Ribble Valley Borough Council
Housing & Development Control

Your ref 3/2022/0136
Our ref D3.2022.0136
Date 31st March 2022

Application no: **3/2022/0136**

Proposal: **Internal remodelling, replacement roof, limited demolition and extension to create two one bedroom apartments on the ground and first floor.**

drawing number
PL 1
revision
B

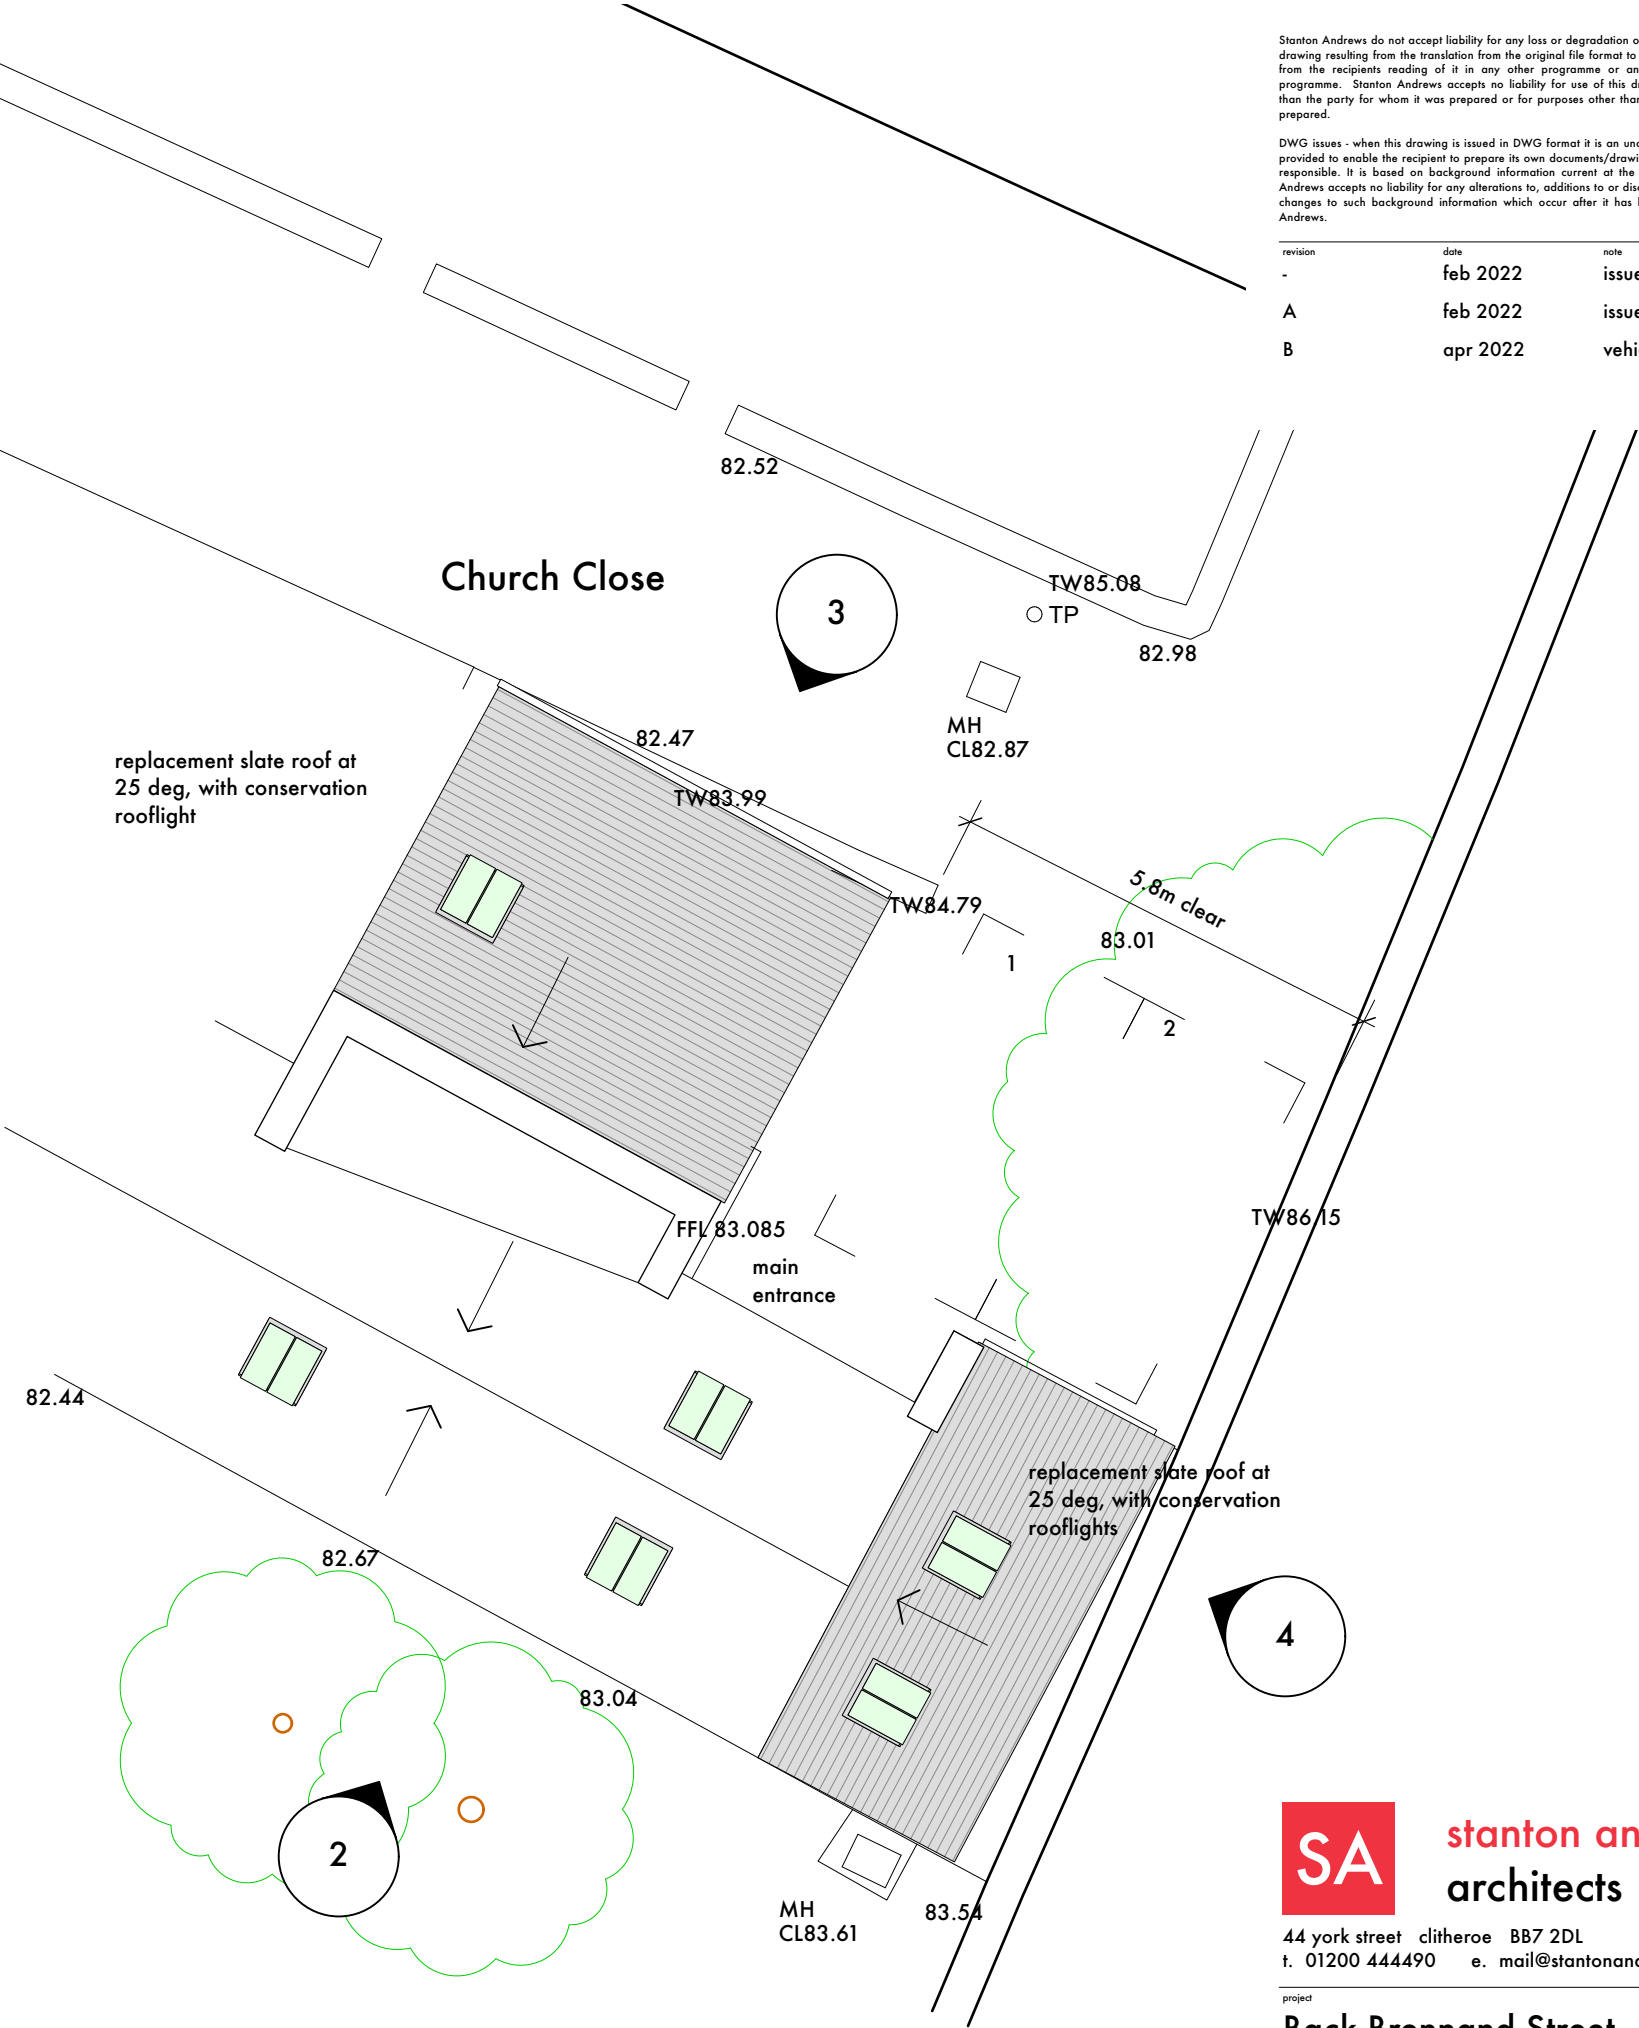
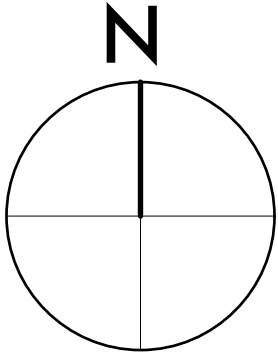
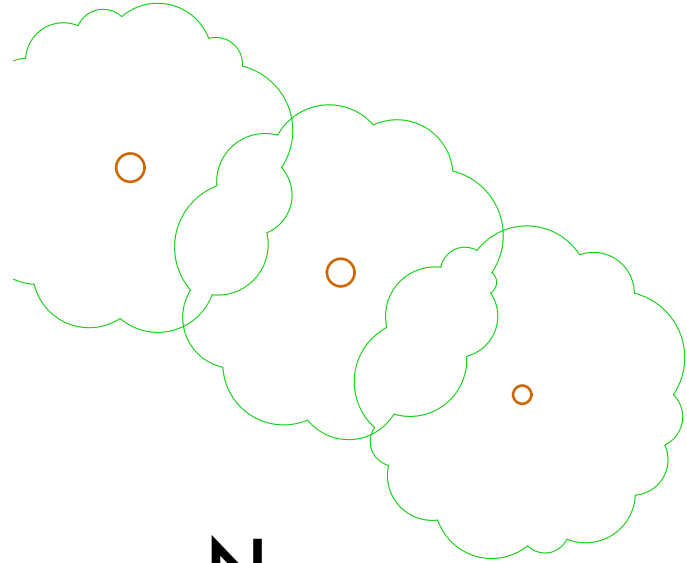
The LHA have reviewed Stanton Andrews drawing number PL1 Rev A titled "Proposed Site Plan" and are aware that the site will provide 2 car parking spaces for the 2x one bed apartments which complies with the LHAs parking guidance as defined in the Joint Lancashire Structure Plan.

However, the LHA have reviewed the dimensions of both car parking spaces and are aware that they measure approximately 5m wide and are 4.8m in length. While this does normally comply with the LHAs guidance for two car parking spaces, the LHA are aware that the spaces are bound on both sides by a wall. Therefore, to ensure that the spaces are usable the LHA will request that the spaces are widened by a further 0.8m making the spaces 5.8m wide.

The LHA suggest that the boundary wall adjacent to the first space fronting the proposal, is reduced in length to ensure the width can be provided. This should be shown on a revised plan.
